**From:** Aahsanur Rahman  
**Sent:** 27 June 2011 10:58  
**To:** Planning  
**Subject:** FW: Proposed extensions to Lakeside School, WGC [N6/2011/0891/FP]

Notice is given under article 10 of the Town and Country Planning (General Development Procedure) Order 1995 that the Hertfordshire County Council as Highway Authority does not wish to restrict the grant of permission subject to the following conditions:

The proposal is for extension to existing classrooms and alterations to external play area at Lakeside School in WGC. The school is situated in Lemsford Lane, which is designated as a local access road. Parking restrictions prevent on street parking outside the school.

LAKESIDE SCHOOL, WELWYN GARDEN CITY
 EXISTING SITE PLAN
 2702_PL02 1:250 @ A3

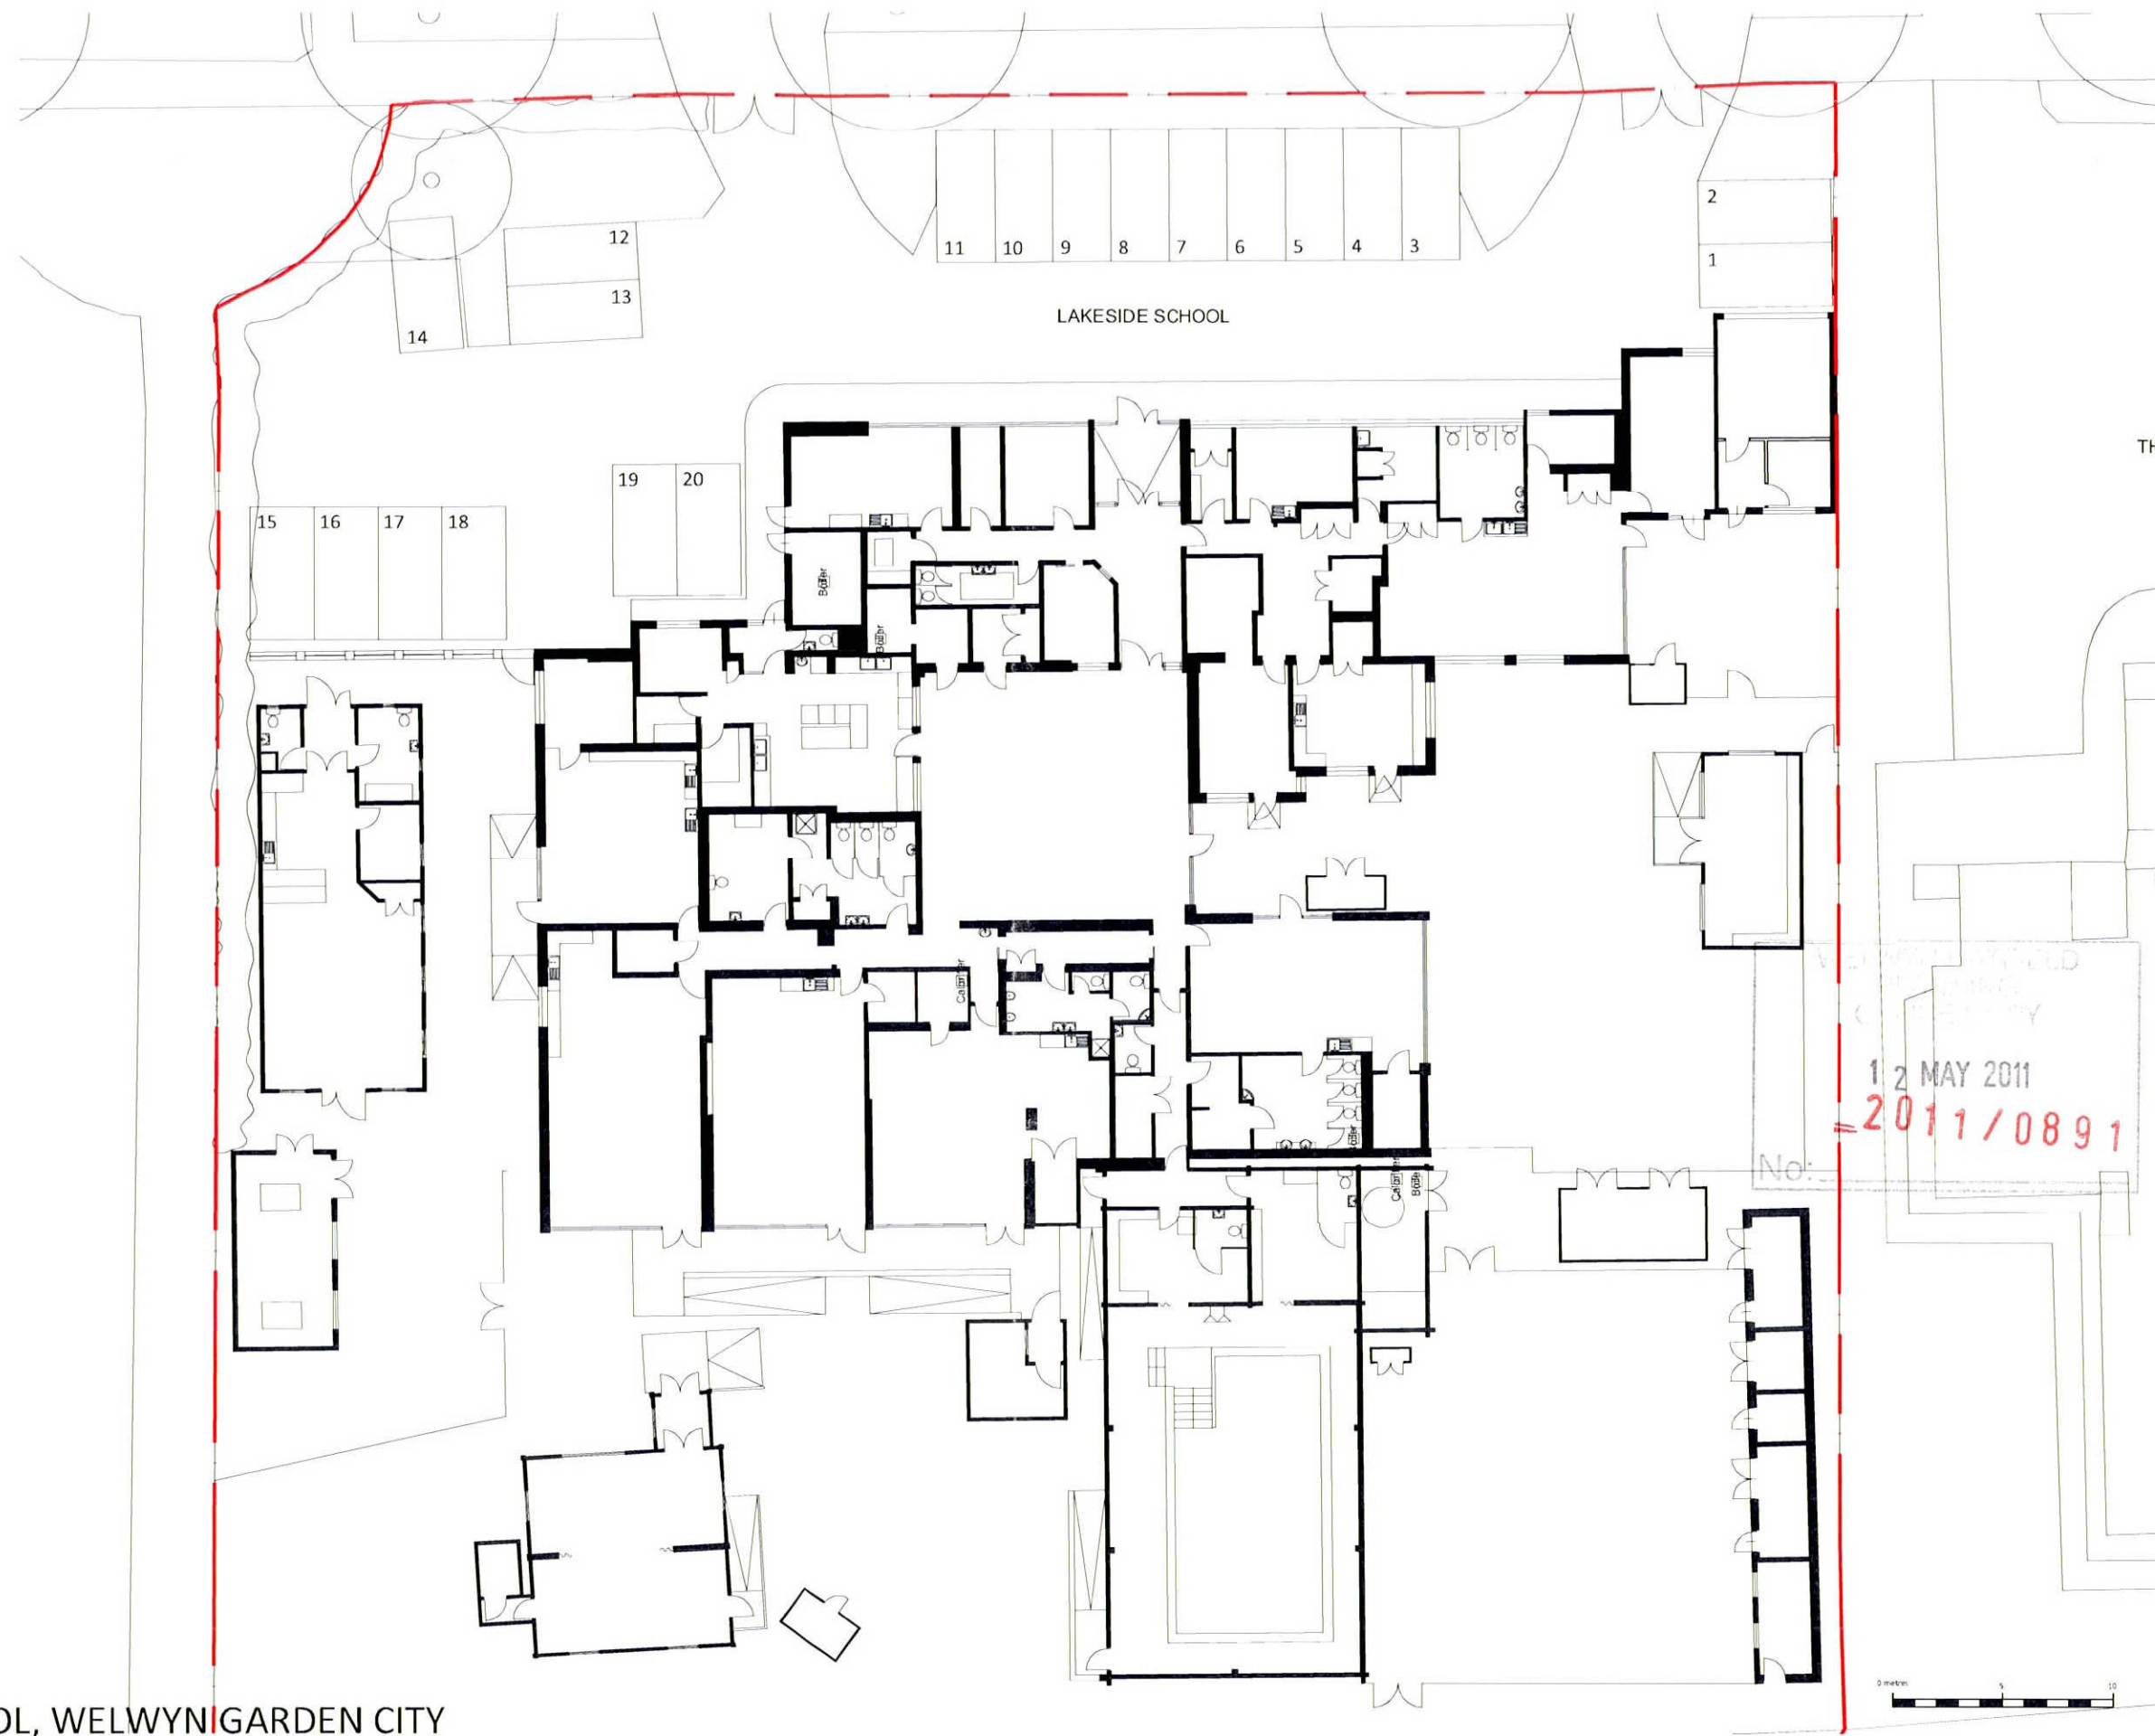
The proposal is for an increase in internal space and is not associated with any increase in pupil or staff numbers. The school has a School Travel Plan which was completed in February 2010 which indicates that the school provides two dedicated minibus parking spaces. My concern is that these are not shown on the proposed plans. I would therefore suggest that any grant of permission is subject to a condition requesting that the parking layout be agreed before occupation and this layout should include for two minibus spaces to ensure that the school can continue to encourage model shift away from the car. The Travel Plan also indicates that currently there are 19 car parking spaces and that this does not always meet the demand from staff. Although parking above the existing level should not be encouraged I would be concerned if there was a reduction in number as this would lead to an increased demand for on street parking in an area which is already heavily parked.

1. C8.12 - The area set aside for car parking shall be laid out and surfaced, in accordance with a scheme which has been submitted to and agreed in writing by the local planning authority before the buildings hereby permitted are first occupied and shall be retained permanently there after for the accommodation of residents/occupiers and shall not be used for any other purpose.
